**OBJECTION**

State Significant Development Application No: SSD-10300

Coffs Harbour Cultural and Civic Space

GORDON ST ELEVATION

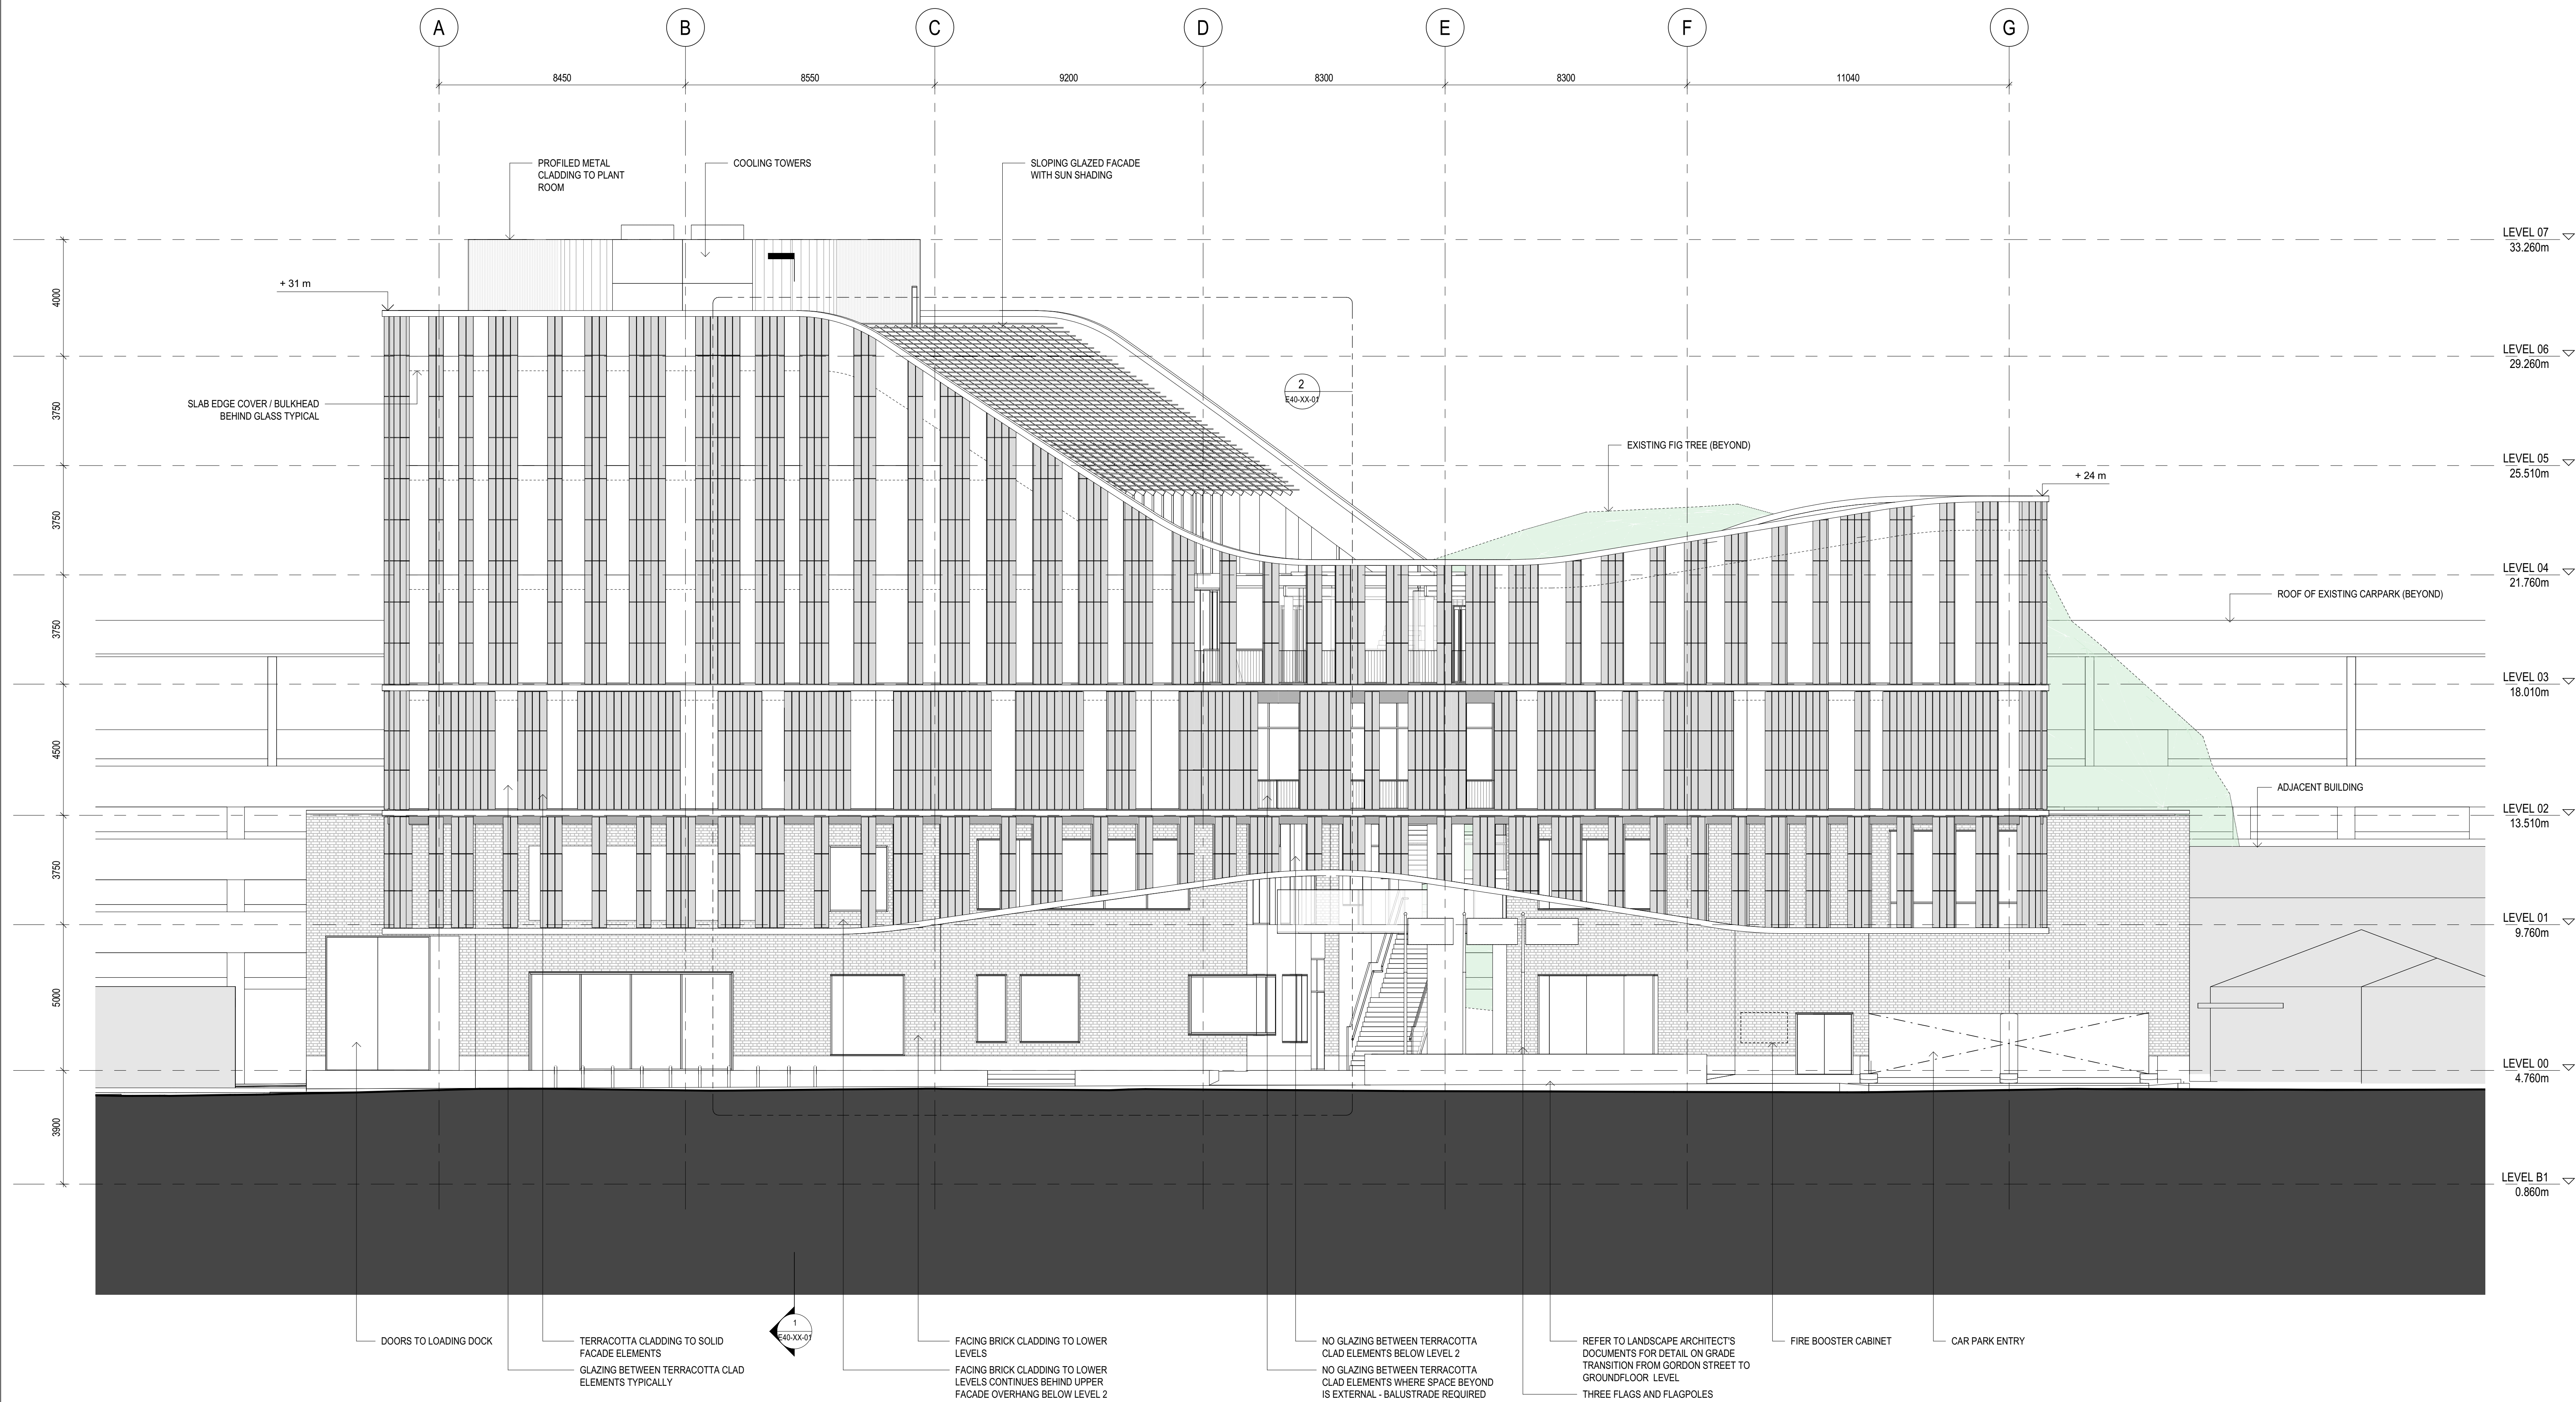
5. The proposed building is out of context in the street with no regard to scale, existing street setbacks, design and general form of adjoining buildings.

SECTION N-S

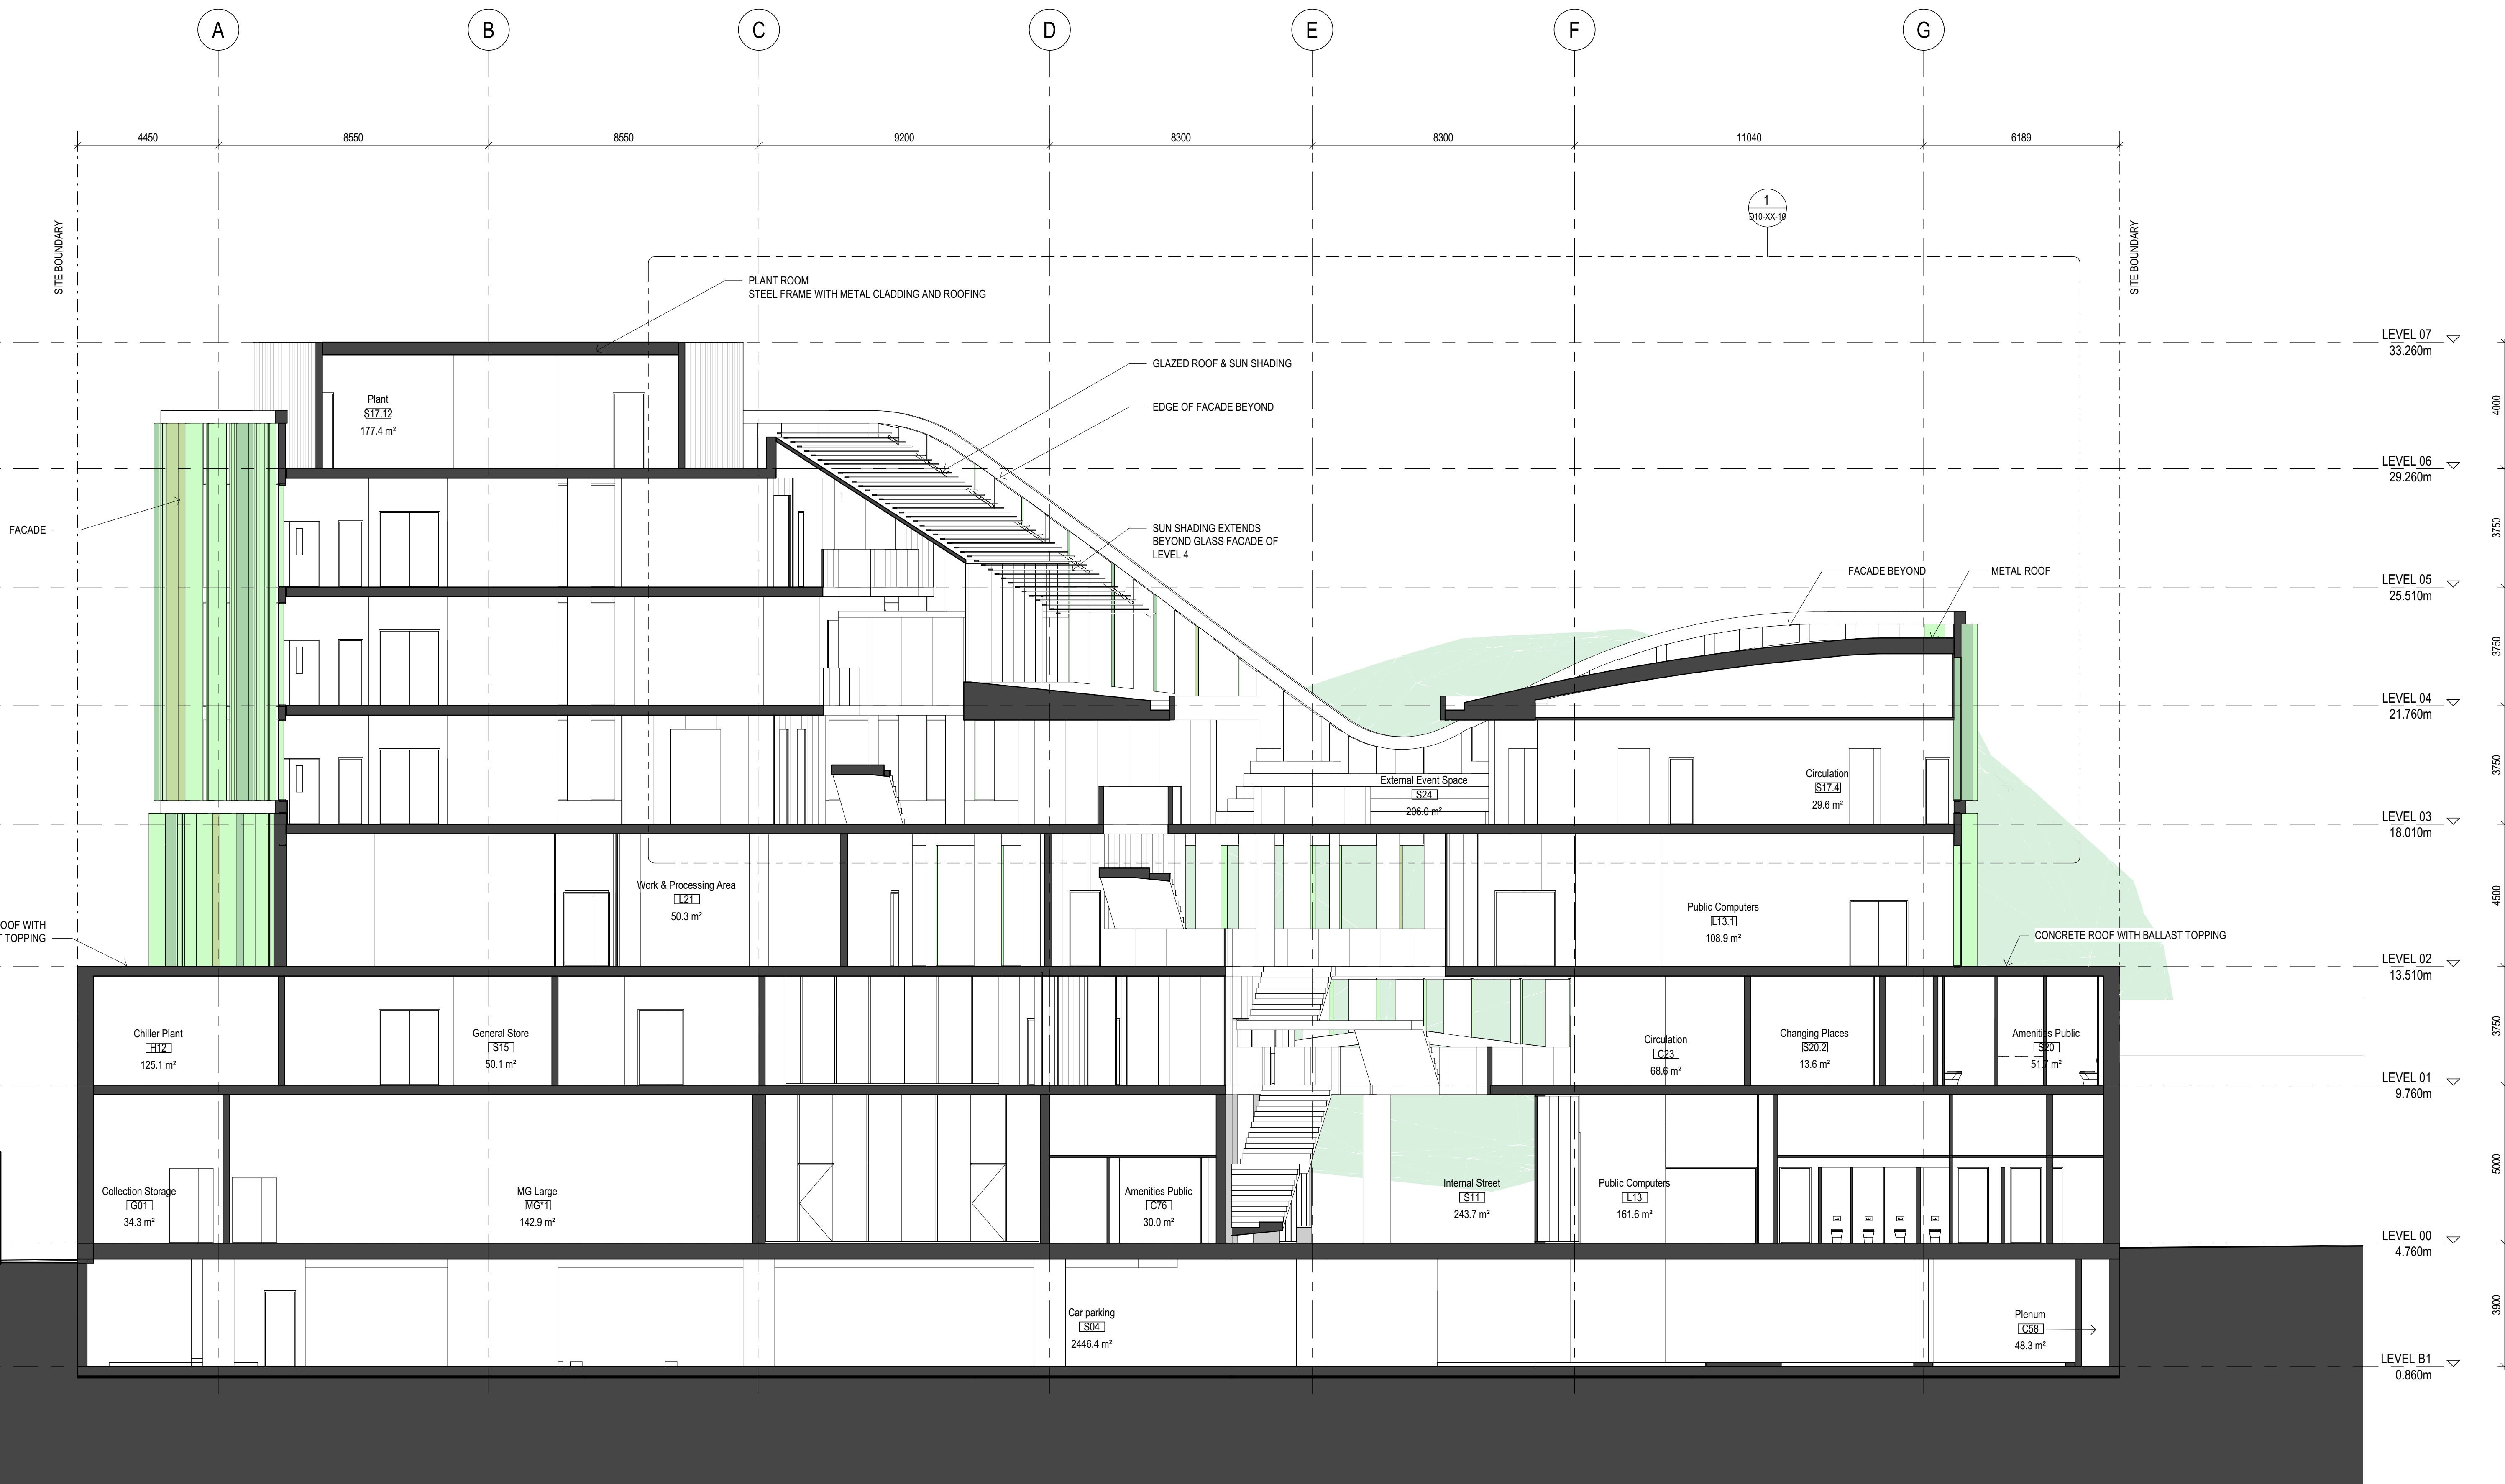
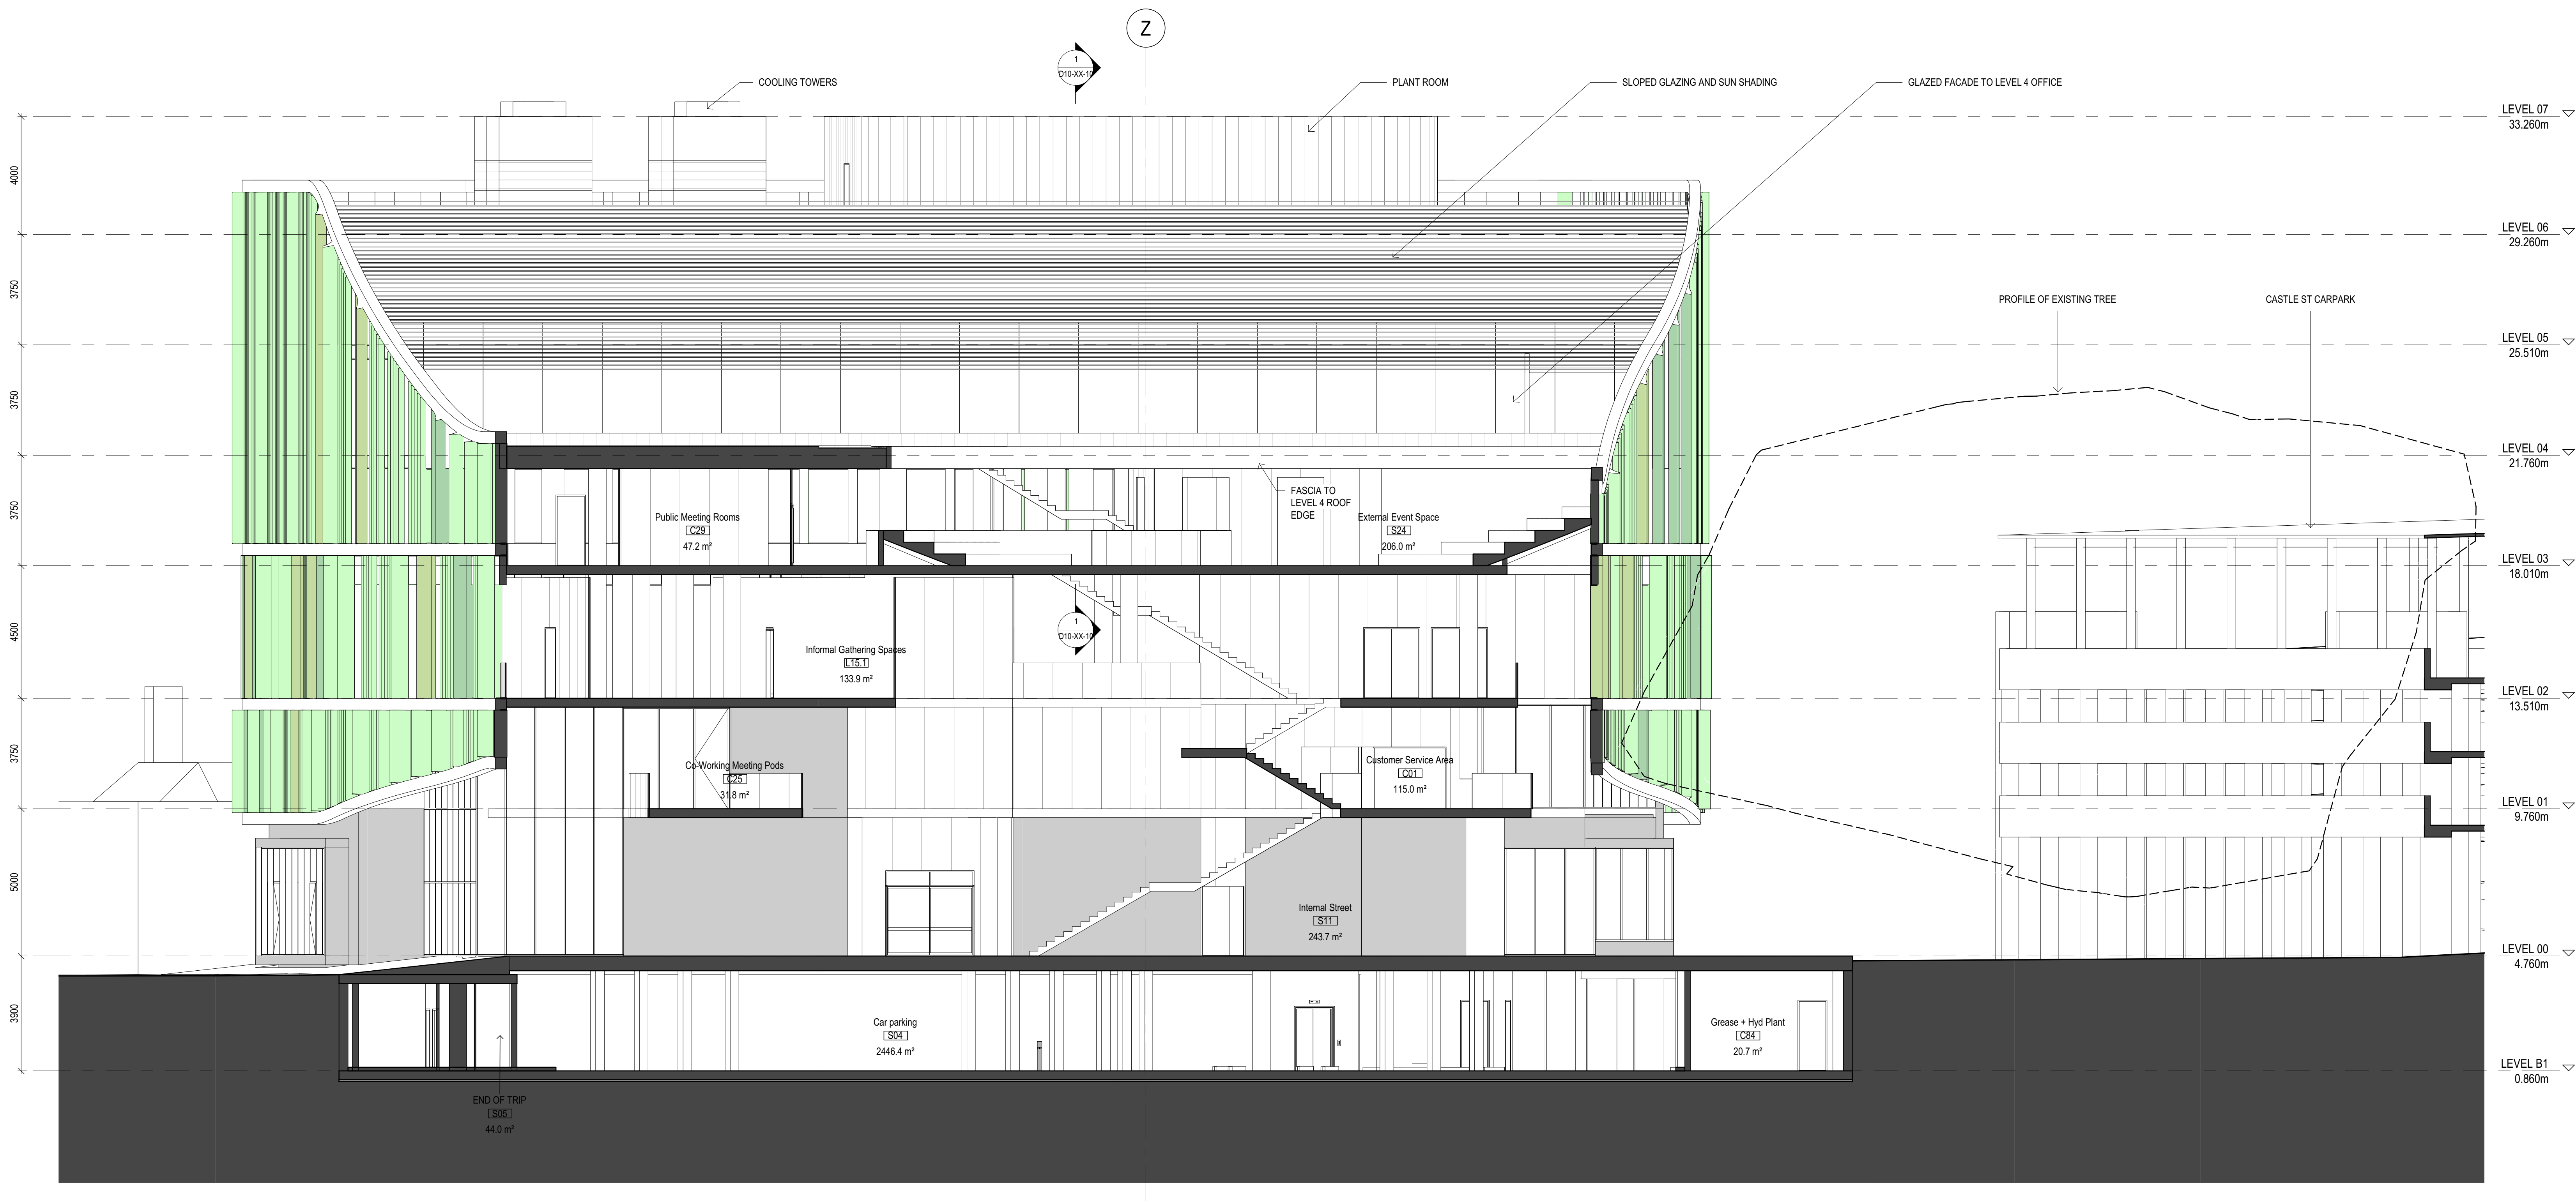
7. As a public building it fails to provide sufficient climate protection for pedestrians during storms and summer sun.
8. The building exceeds the height restriction of 28m set down in Council's own planning controls. Council's argument for variation is not satisfactorily justified and is not consistent with the objectives of the Environmental Planning and Assessment Act 1979, which requires the "the orderly and economic use and development of land". Council should not receive preferential treatment.
